Submission Form

PCU039591

Epping to Thornleigh Third Track Proposal. Application number SSI 5132.

Concept design drawing of proposed changes to Beecroft Station (Parsons Brinckerhoff 9/3/12). Former side platform shaded in pink.

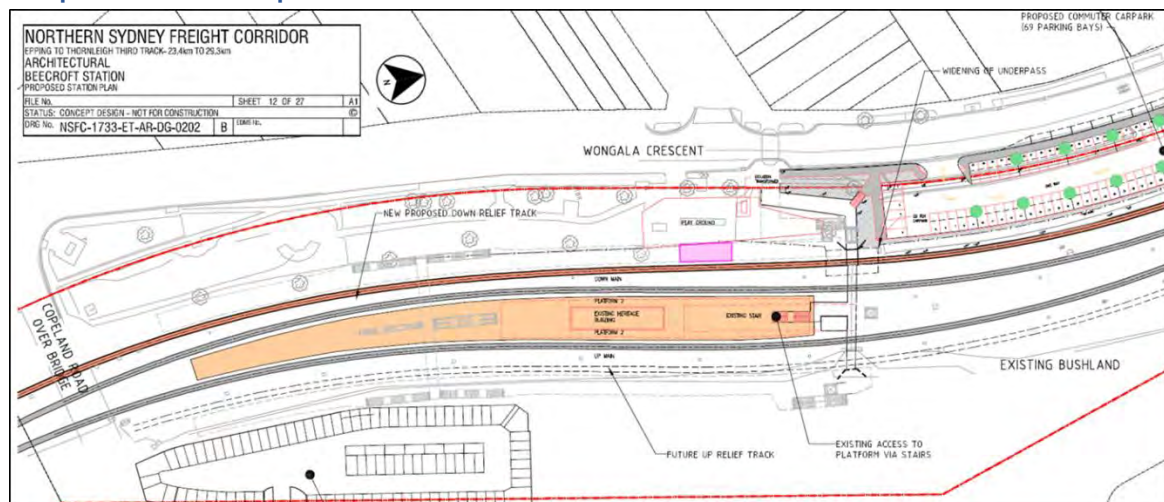
- There has been inadequate assessment of the project's impact on the fabric of the Beecroft Cheltenham Heritage Conservation Area (HCA).
- The plan given for Beecroft Railway station Precinct is vague. The relationship to the trees, playground and original 1895 platform located south of the present station is not shown. A fourth track is shown on the eastern side. The plan does not include urgently needed lifts to allow disabled access at Beecroft Station.

- Beecroft Station Gardens have a heritage listing with Hornsby Council but the impact on them has not been adequately addressed. No arborist's report is given for the trees which will be removed.

Elevation of proposed Cheltenham Station concourse

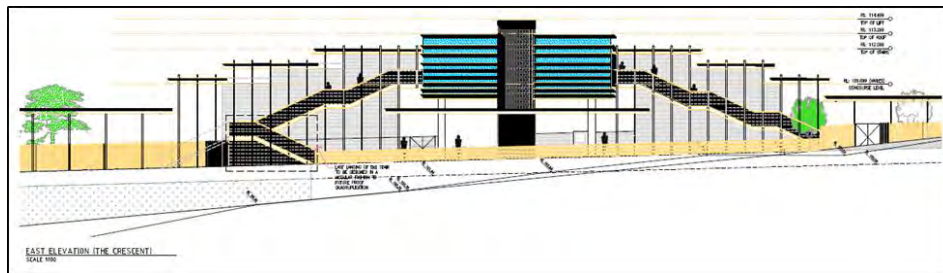
- The proposed redevelopment of Cheltenham Station shows no regard for the HCA. The visual impact of the proposed 13m high glass and steel concourse is totally unacceptable in this HCA.
